From: [Jon N](#)
To: [East Pye Solar](#)
Cc: [REDACTED]
Subject: Subject: Formal Objection to East Pye Solar Project (Reference: EN0110014) – Visual Encroachment and Heritage Settings Harm at Hawes Green (Site 8)
Date: 20 September 2026 20:10:30

I am writing to register my formal objection to the proposed **East Pye Solar Project**, specifically concerning the unacceptable, unmitigated visual impact of **Site 8** (sub-sites 8A and 8B) on **Hawes Green** within the **Shotesham Conservation Area**.

Figure 30. Site 8 showing Grade II Listed Buildings, Conservation Areas and Non-Designated Heritage Assets

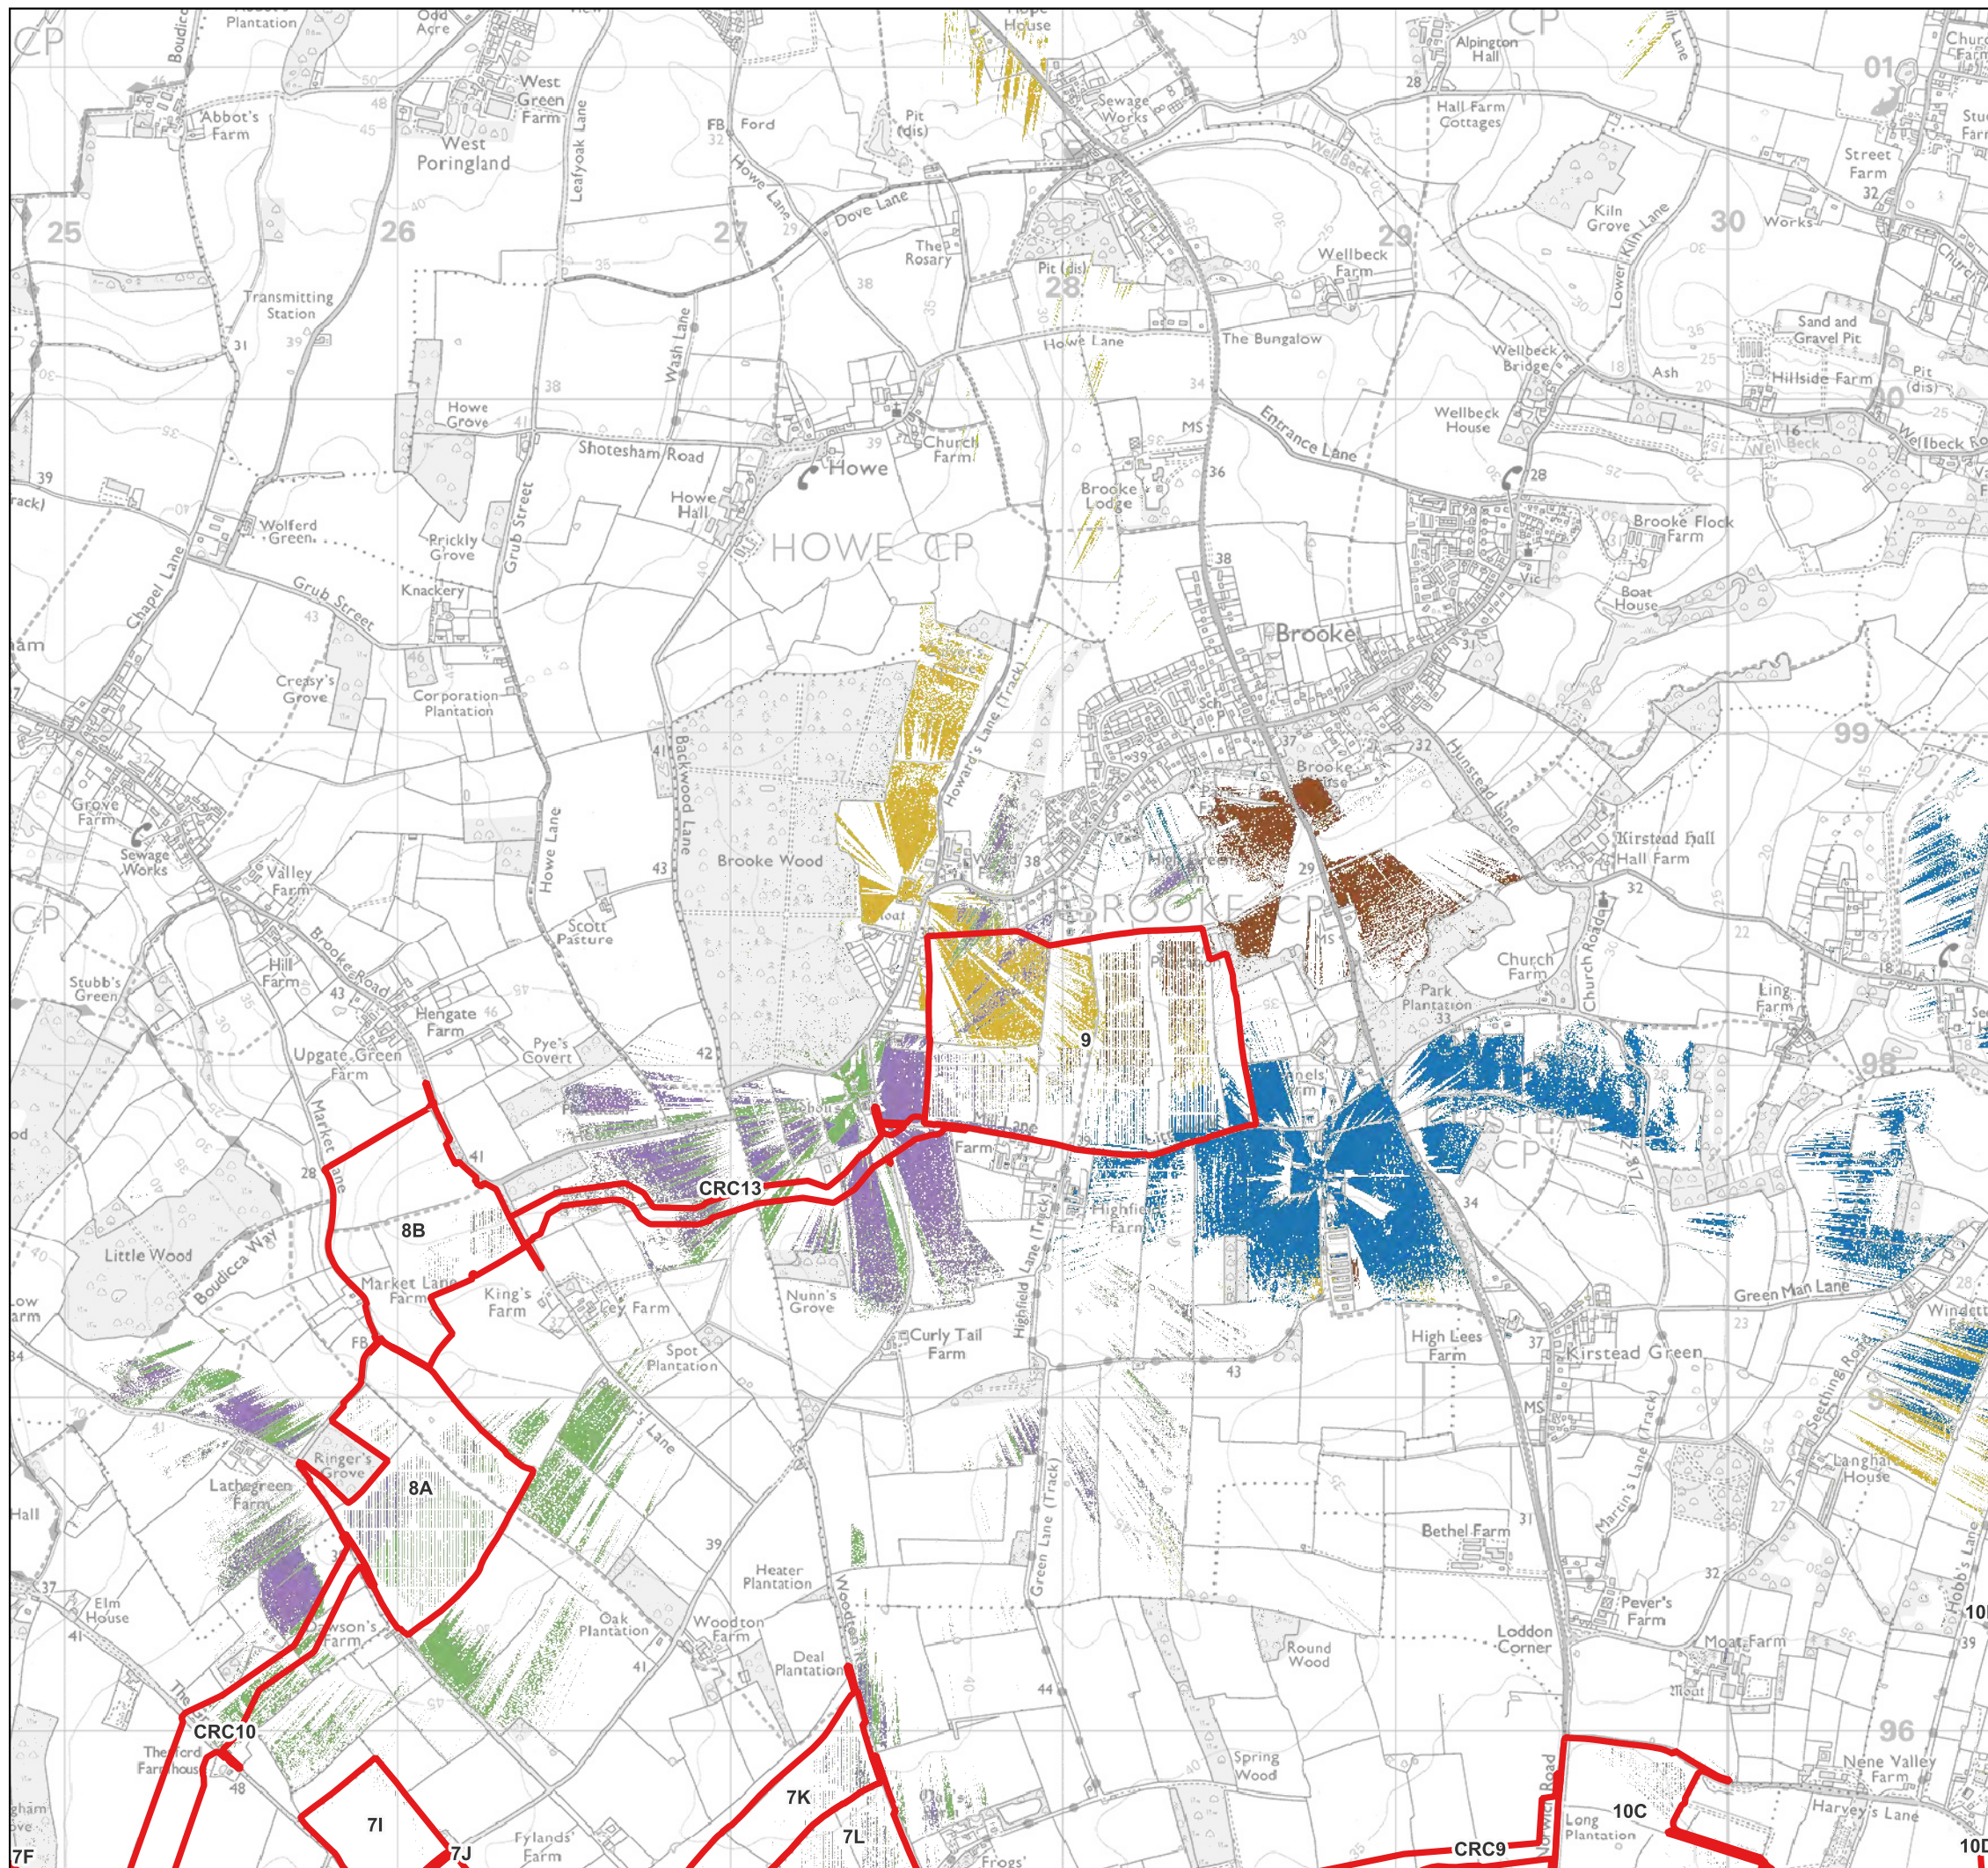
I am a permanent resident of Hawes Green, living within a highly sensitive and protected historic landscape. Our properties sit in immediate visual and historic alignment with an exceptional national heritage cluster, including the Grade II* listed **St Mary's Church** and the Grade II listed ruins of **St Martin's Church**.

Under Section 66 of the Planning Act 1990 and Historic England's GPA3 policy framework, the rural backdrop and immediate approach to our homes and medieval churches are strictly protected. The developer explicitly admits that **"glimpses" and "glimmers"** of the industrial solar arrays will pierce the tree lines right outside St Mary's Church path. An admission of a glimpse is a legal admission of an unmitigated line of sight. Introducing a massive, metallic, industrial infrastructure layer into this historic viewshed shatters the rural tranquility and group value of this designated Conservation Area.
